Recommendation Report for Planning Permission for Works or Extension to a Dwelling

REF NO: M/73/19/HH

LOCATION: 7 Sea Way
Middleton-On-Sea
PO22 7RZ

PROPOSAL: Erection of a single storey outbuilding to be used as a washroom/garden studio

Garden studio & washroom

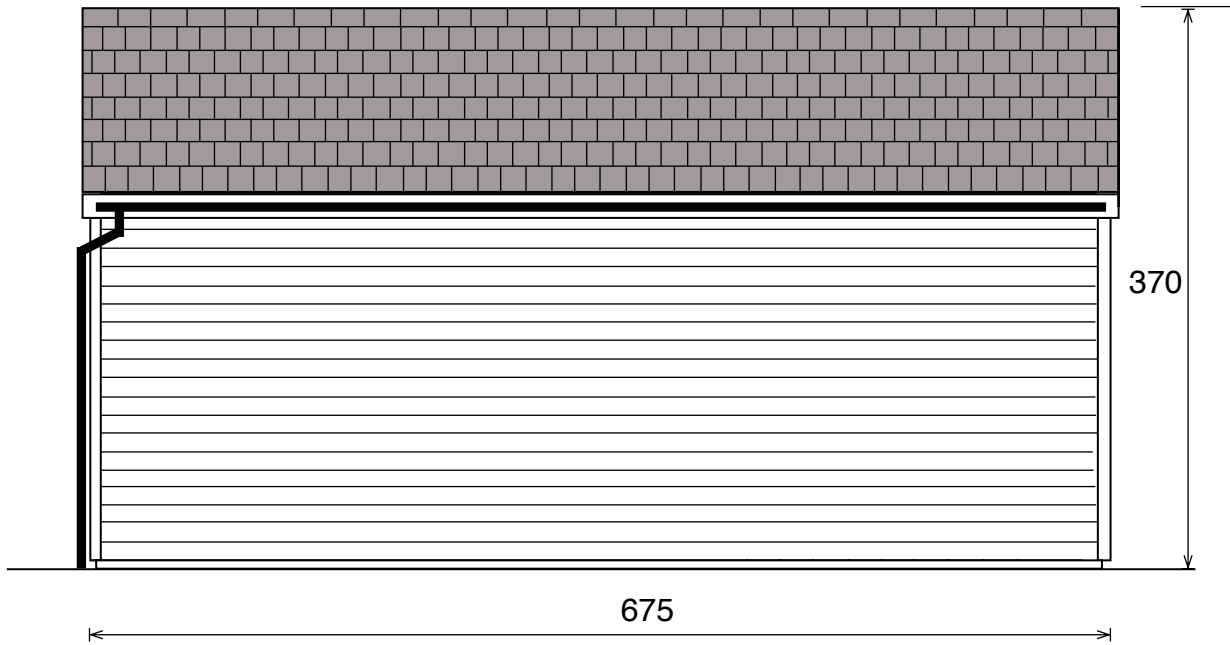
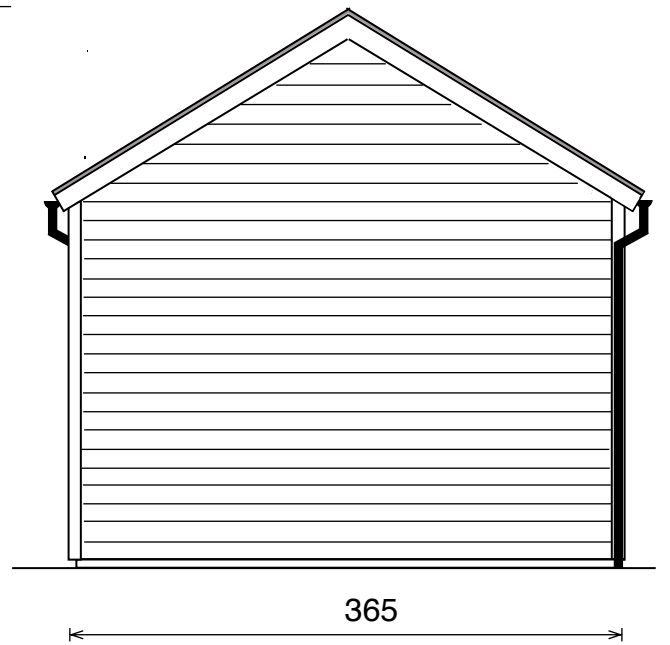
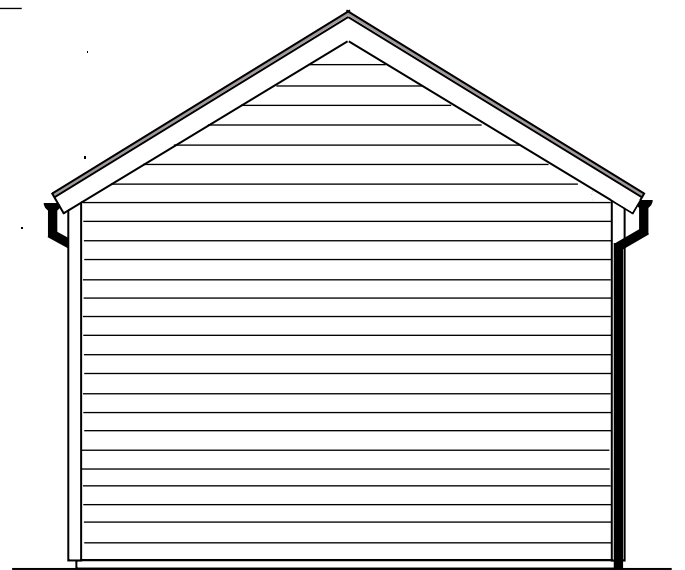
As originally submitted, the application proposed a steel panelled roof, however, this was deemed to be inappropriate for the locality. Therefore, the application was amended to change the proposed materials to use natural slate, which is considered more acceptable within the locality. This is due to their being examples of similar materials in the area, and the proposed material being of better amenity value than the steel panelling previously proposed.
